Your Ref: OWPC18684
Our Ref: BR/229/17/PL 11-08-2017
Please ask for:
Mr S Davis

Erection of 3 No. dwellings, 1 No. detached garage, parking & alterations to existing access & driveway (resubmission following BR/200/16/PL).

Land to rear of 41 - 47 Pevensey Road Bognor Regis

Thank you for your internet representation made on 7th June 2018 which has been recorded as '**an objection**' with the comments as follows:

DRAWING TITLE	
Block & Location Plans and Site Section	
DATE	SCALE
Feb 18	1:200 @ A1
JOB NO.	DRAWING NO.
1615	2.13
	CHECKED BY
	REVISION
	DRAWN BY
	GIM

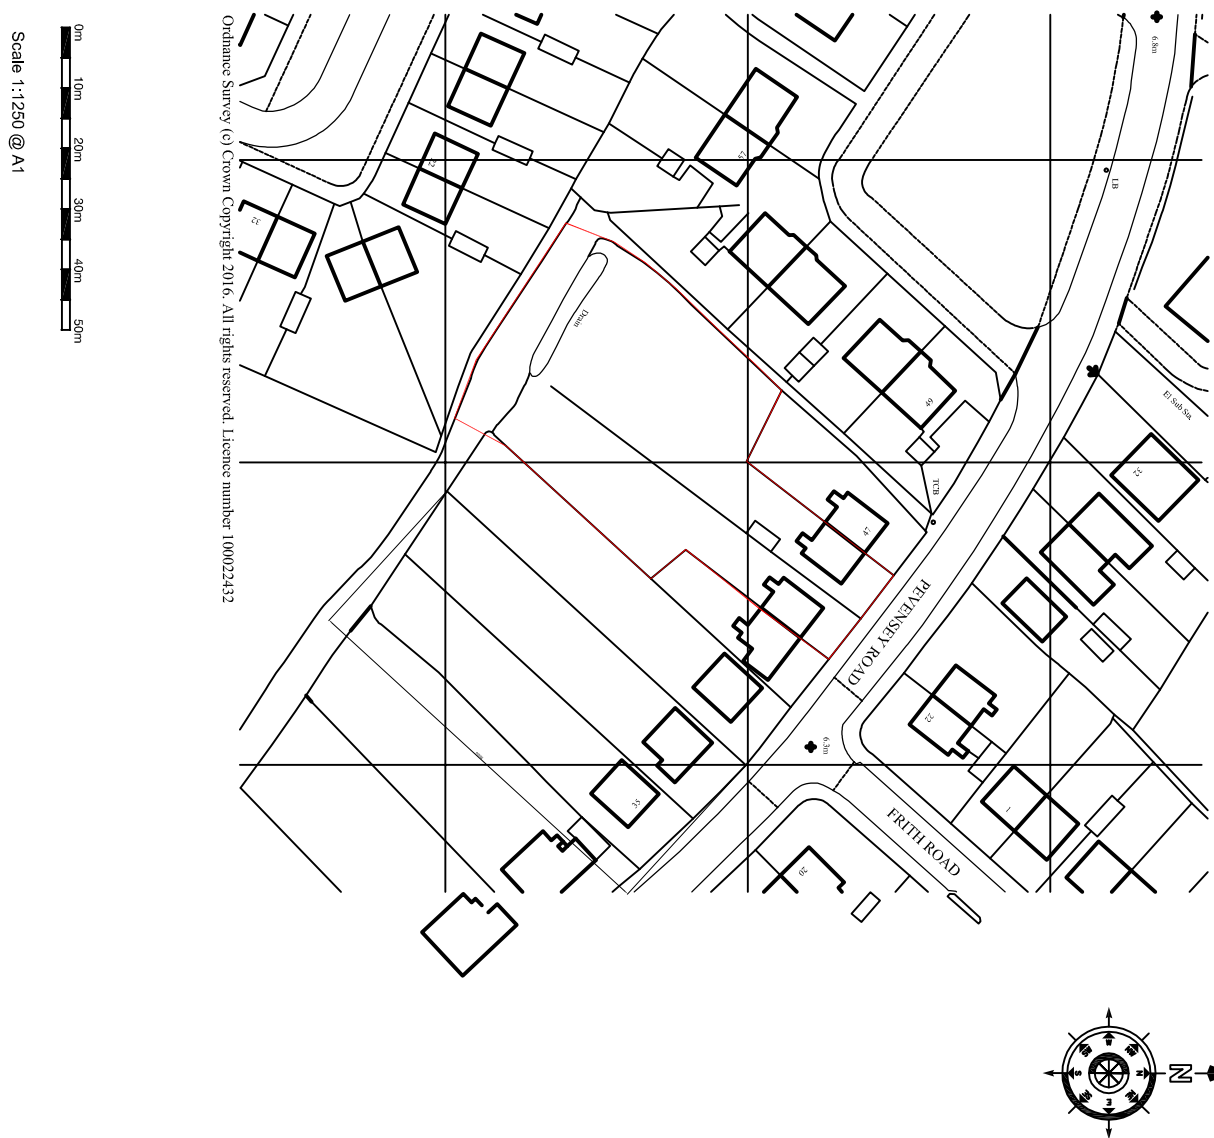
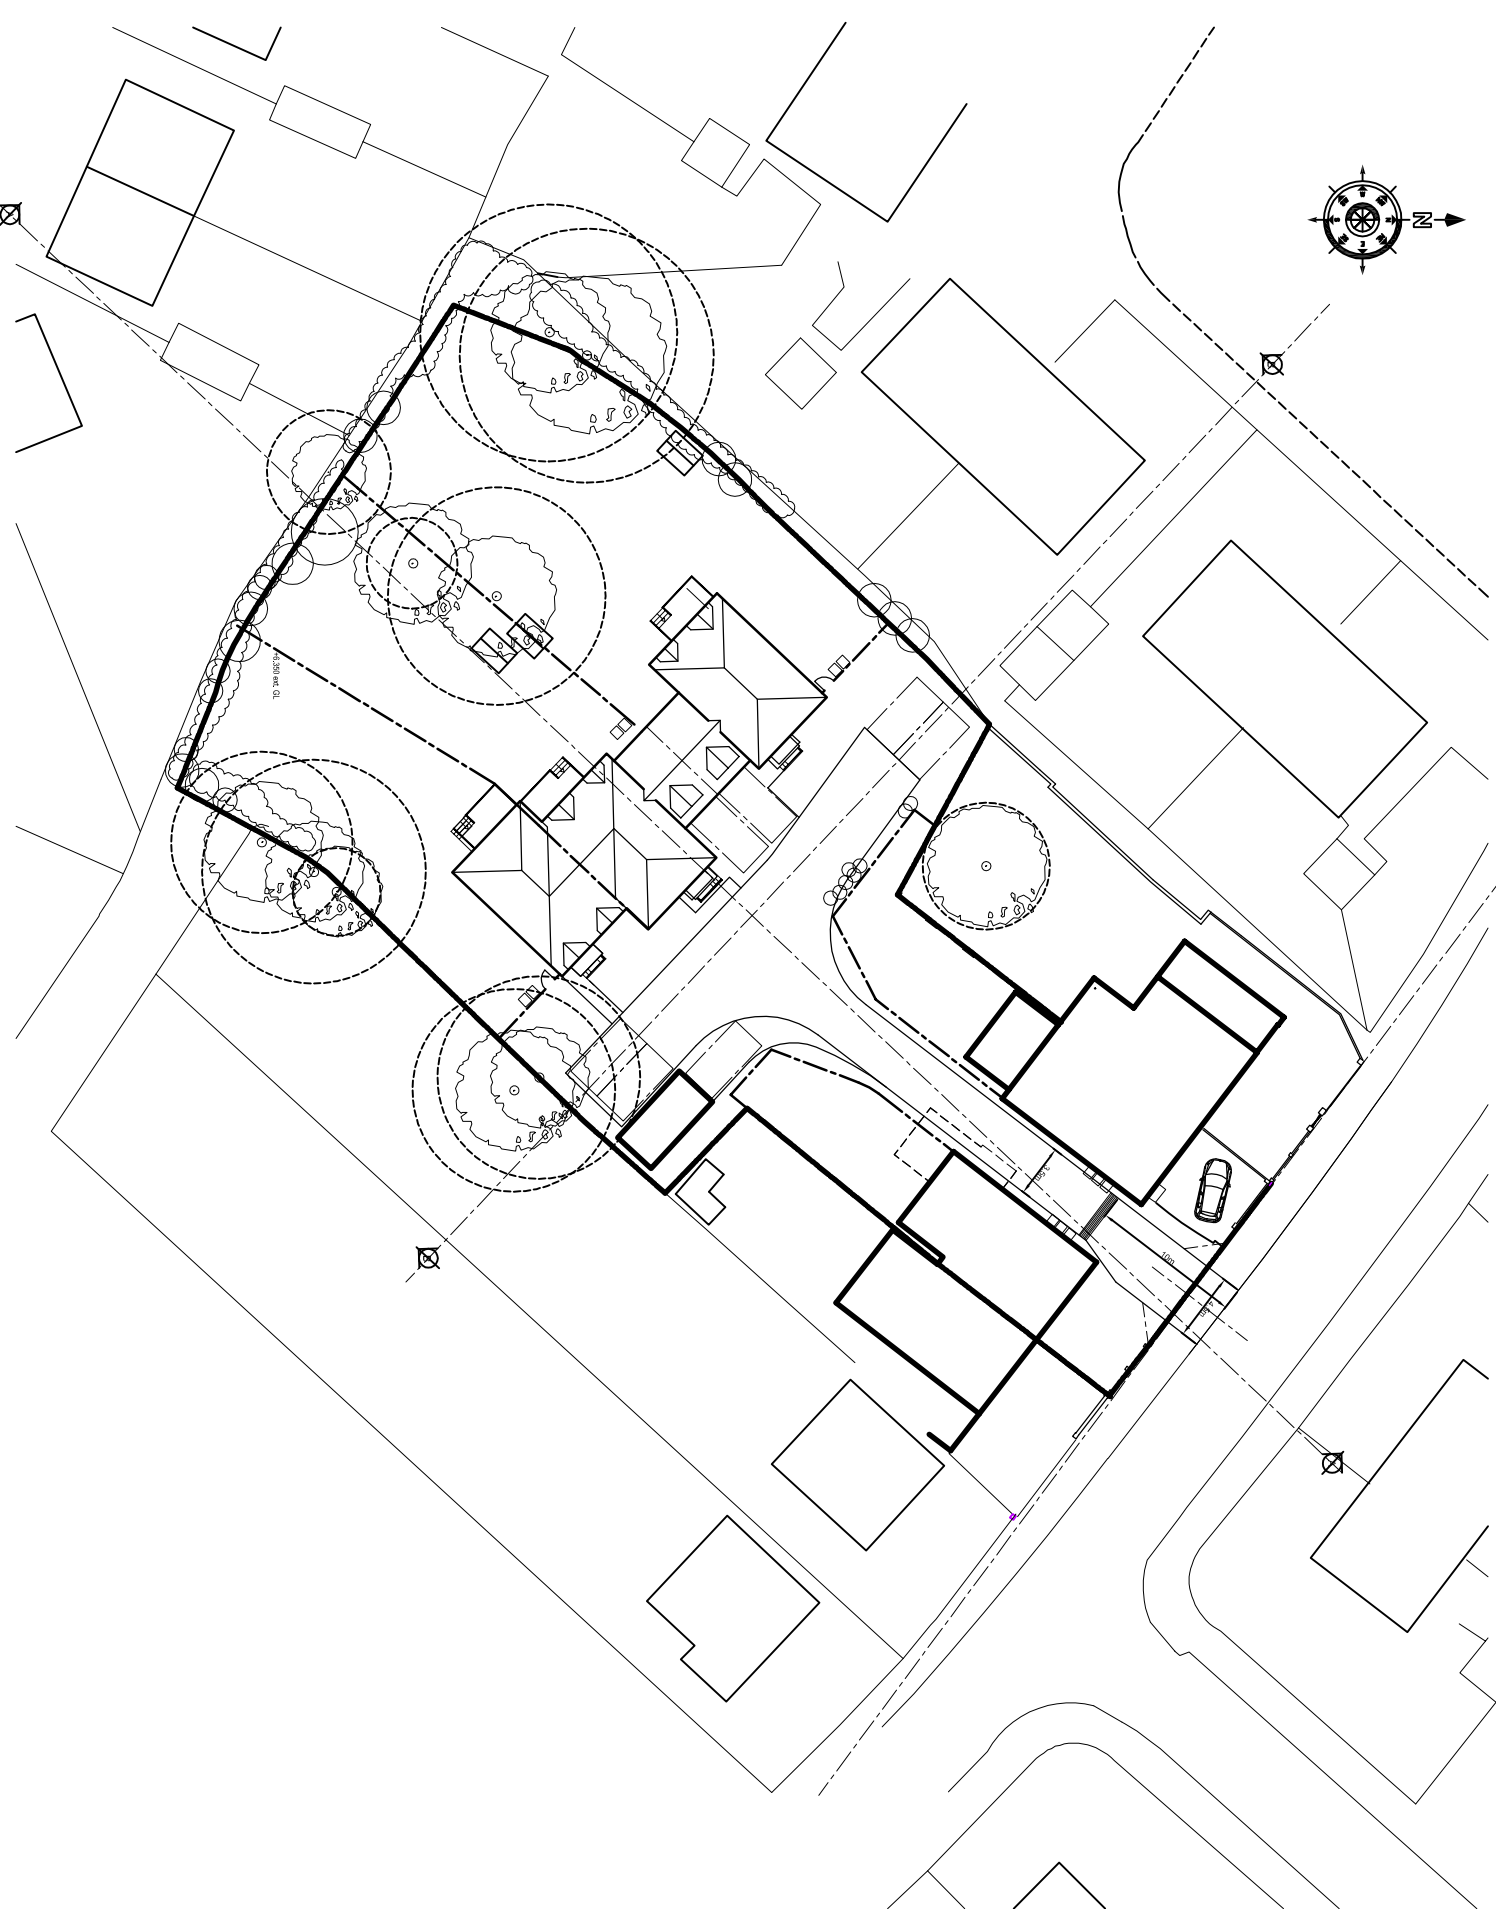
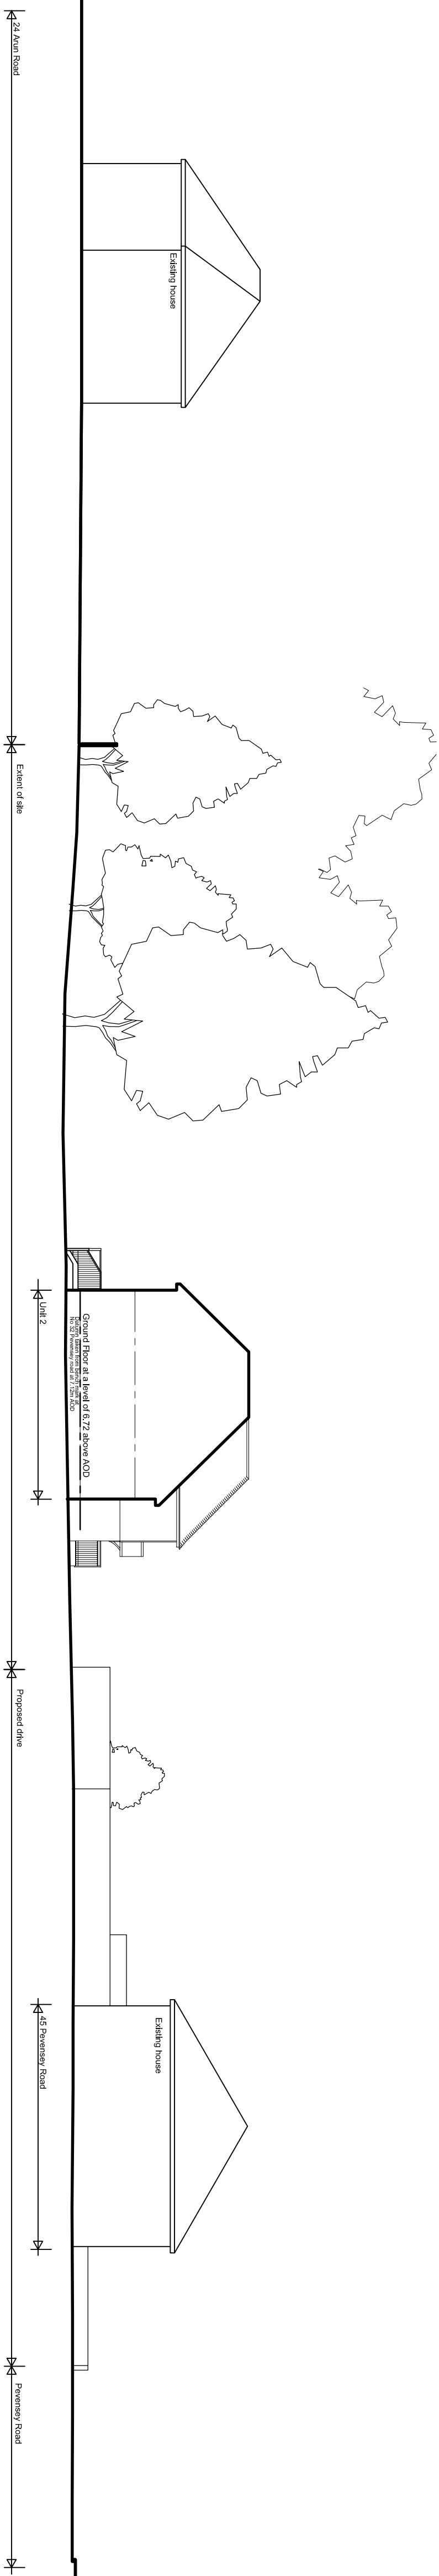
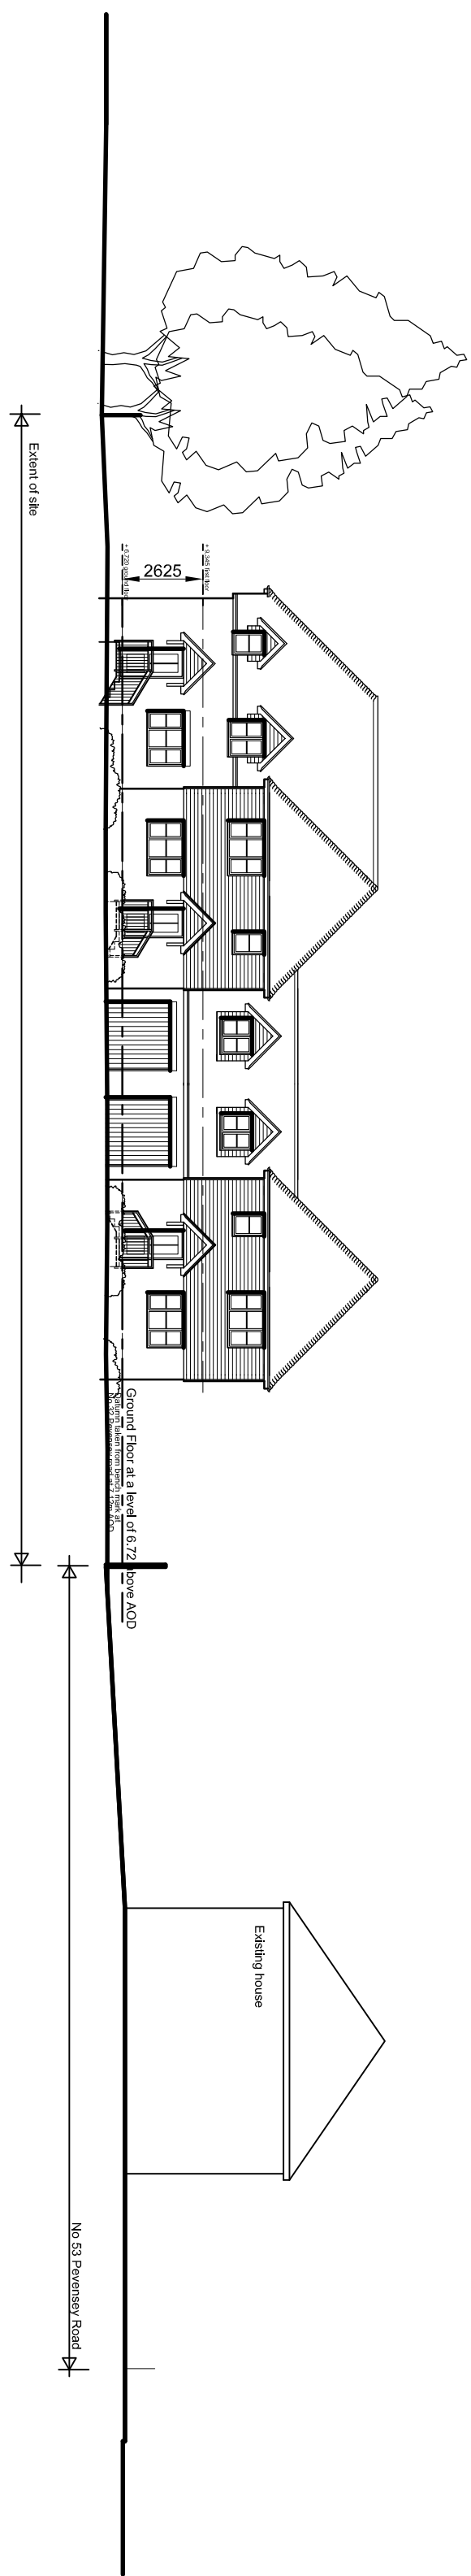
We strongly object to the revised plans, the points Mr Harverson made about reducing the number of dwellings and by doing this then being able to move all of the car parking spaces and separate garage out of the two protected tree RPA's have still not been achieved.

The architect has still for some reason left the parking spaces and the detached garage exactly where they were before, still on top of the protected trees roots, still exactly where Mr Harverson requested them to be removed from!

We object to plot 3 being built so close to the protected trees and still having the parking bays and detached garage on top of the roots this will damage them and harm the trees. The protected trees will also still cause intense shading of gardens especially in plot 1 & 3, as objected to before, as the Oak and Horse chestnut tree especially are growing in height & density all the time so the new occupants can ask for them to be cut down as natural light can't get through due to the sheer size of them.

Mr Harverson requested a east to west cross section drawings as he didn't think a "no dig"situation was viable for the parking bays because of the levels. Is this online anywhere yet for the new tree officer to follow up?
